**MIXED USE DEVELOPMENT (SSD 8019 MOD 1) 21 HONEYSUCKLE DRIVE
NEWCASTLE**

I refer to your letter of 13 February 2019 advising KDC Pty Ltd, on behalf of the applicant Doma Holdings (NSW) Pty Ltd, has submitted an application to modify the development consent and inviting City of Newcastle to comment.

LEVEL 01 - FLOOR PLAN

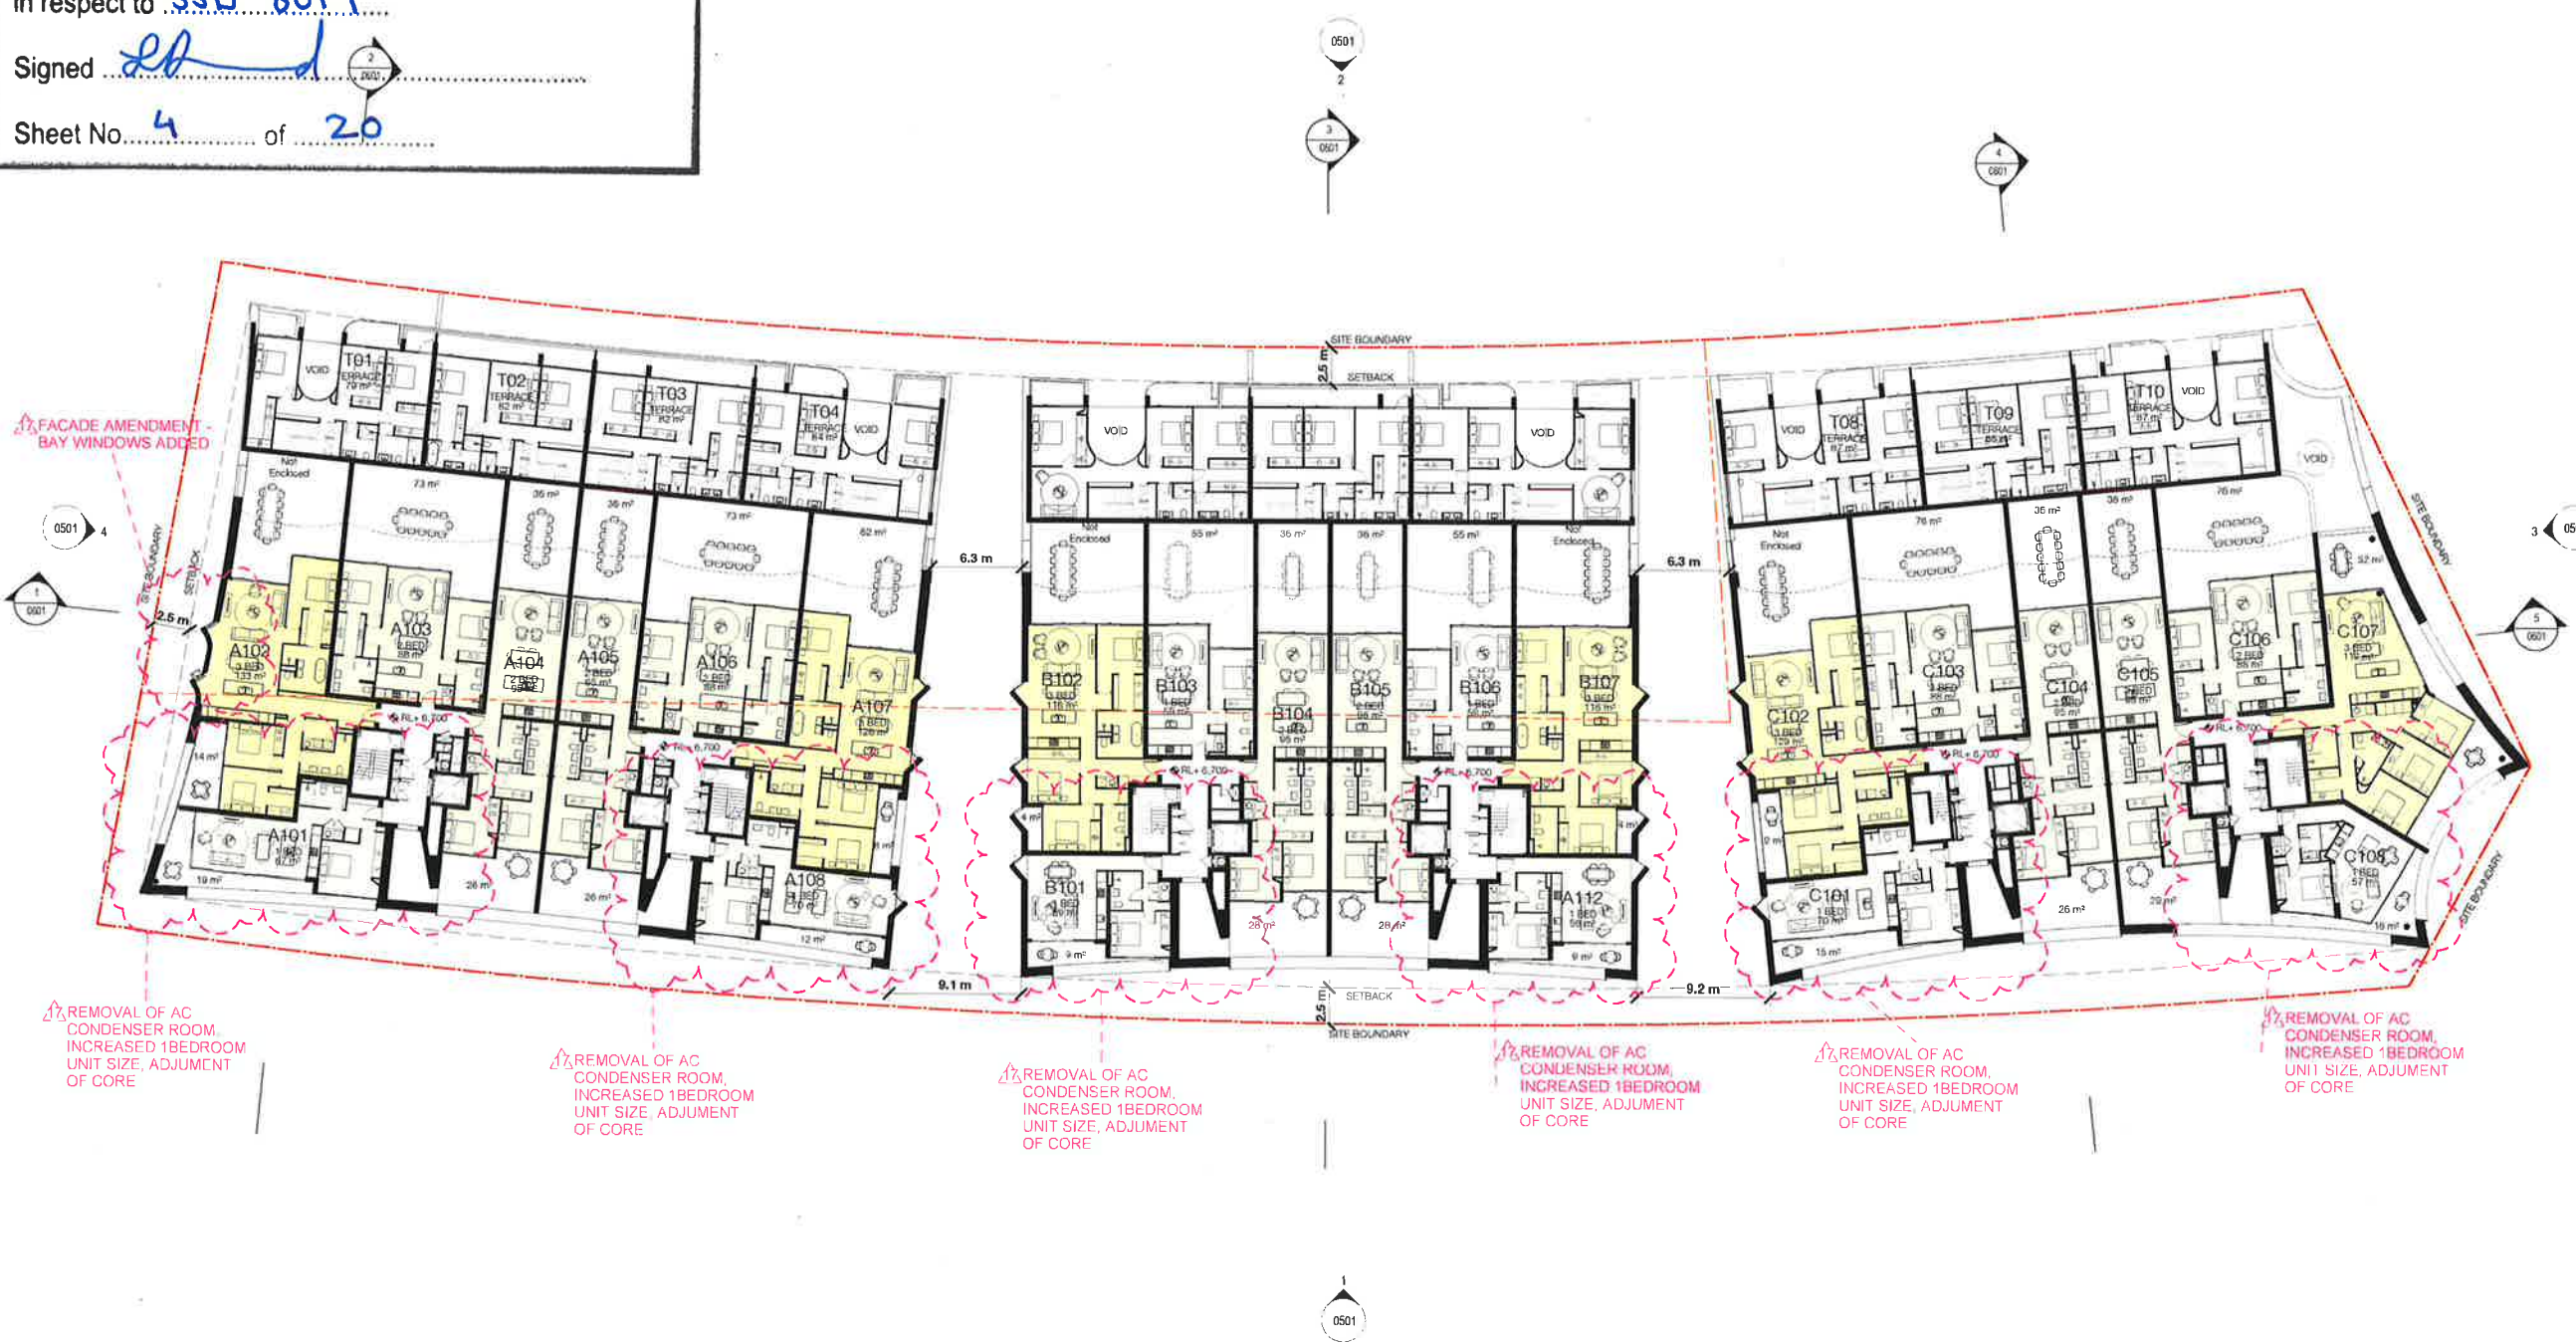
In addition to the proposed design modifications indicated in the SEE, the submitted plans include amendments to the commercial tenancy balcony on the ground floor plan and the inclusion of bay windows to the western elevation at level 1 which have not been acknowledged.
